From: Heritage Hills Neighborhood Association [hhna@comcast.net]
Sent: Tuesday, January 29, 2008 5:17 PM
To: Cloud, Jack W.
Cc: Killin; Deshler; Davidson; Carnett; Lehner, Catalina L.
Subject: Concerns About DRB Hearing on Ventura Plaza (Project #1006602)

Heritage Hills Neighborhood Association (HHNA) is concerned about how the City will act to protect our Neighborhood interests.

The Inter-Office Memo from Senior Planner Catalina Lehner has an Informational Note indicating that the Developer has agreed to request an Administrative Amendment after DRB action is complete, and HHNA would like to add our comments on these three items. Attached is a copy of the viewgraph slides that we propose to use for this purpose.

DRAWING TITLE
INTERIM DRAINAGE MANAGEMENT PLAN

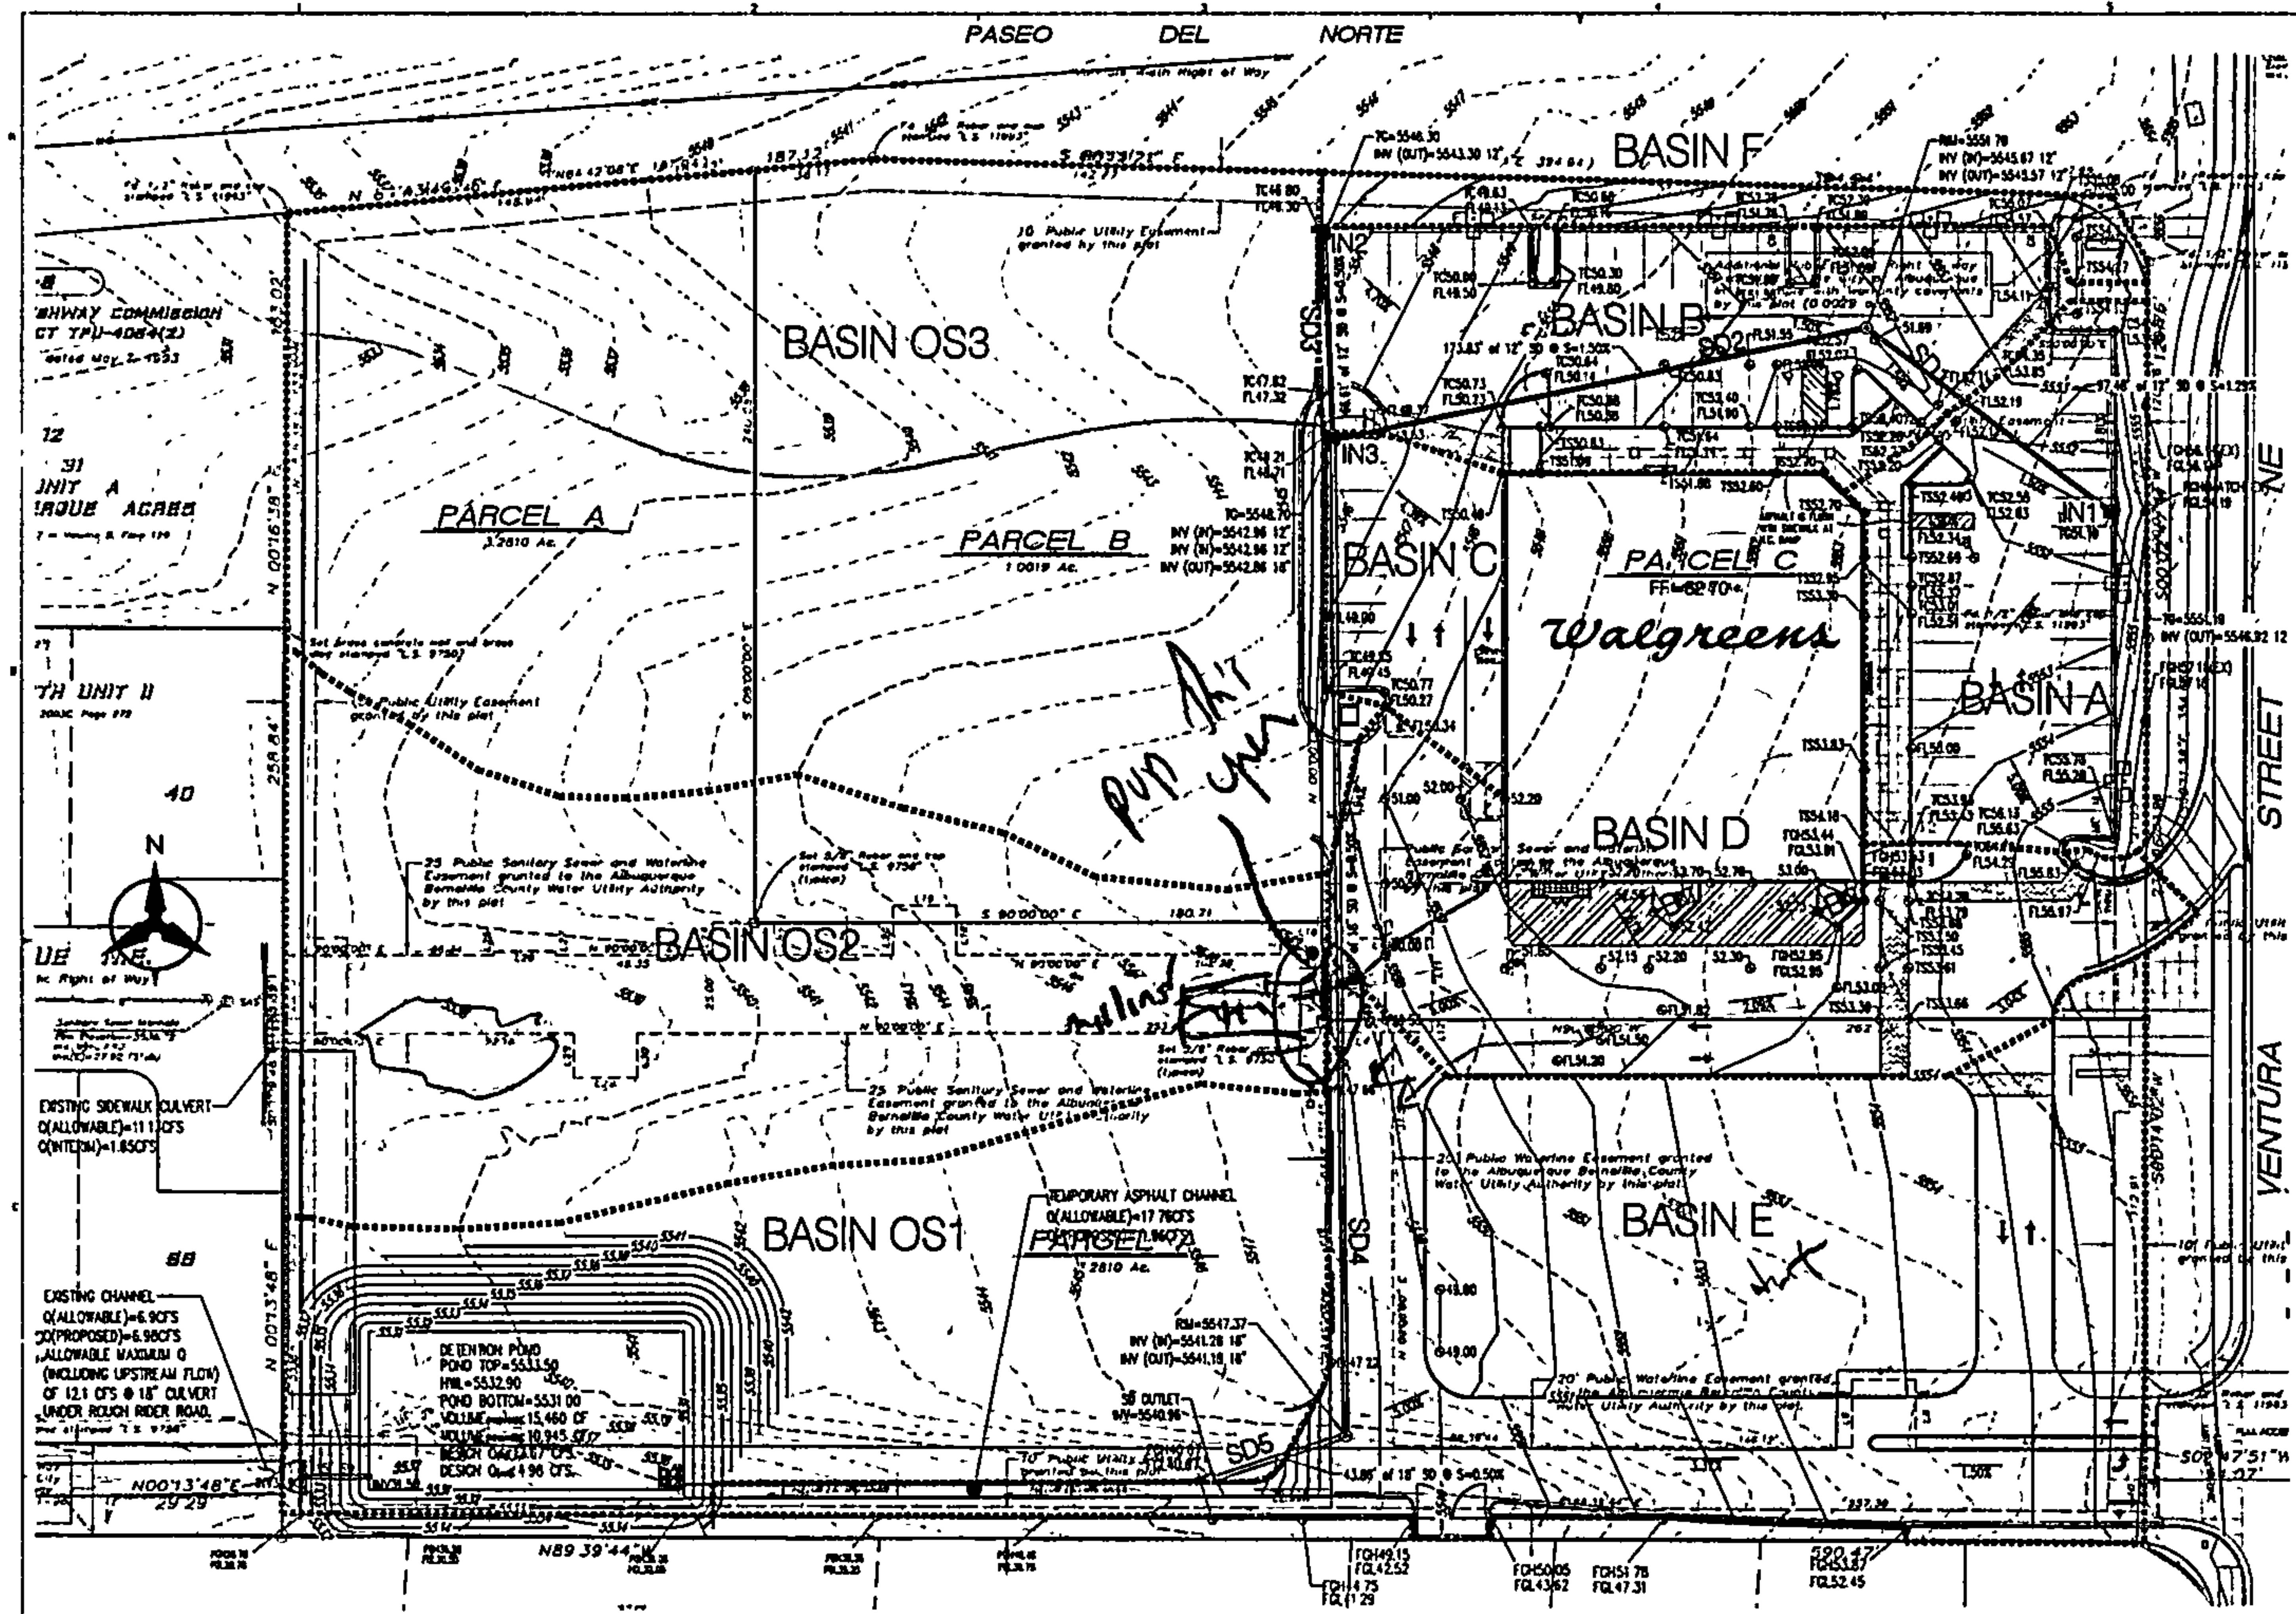
During the meetings and discussions with the Developer(s) and their Representatives leading up to and after the EPC Decision, issues that have not been left addressed. One of these issues was identified as the province of the DRB: to be addressed by that Board. The principle issue of concern was the control of drainage from the development site. There are two specific concerns about the drainage that affect the Neighborhood:

1. What will happen to the drainage ponding that currently exists at the east end of Palomar Street where the residential neighborhood begins. This design currently uses Palomar street as a run-off conduit which in turn causes flooding in the lowest yards near Barstow St. where the streets curves. This ponding for drainage down Palomar must be eliminated before the entire site is covered with parking lots and roofs.

2. The current elevation plan for the site will not insure that the drainage to the north of the site will be diverted to the existing, lined arroyo north of the Palomar residential area. This must be addressed as part of the drainage plan.
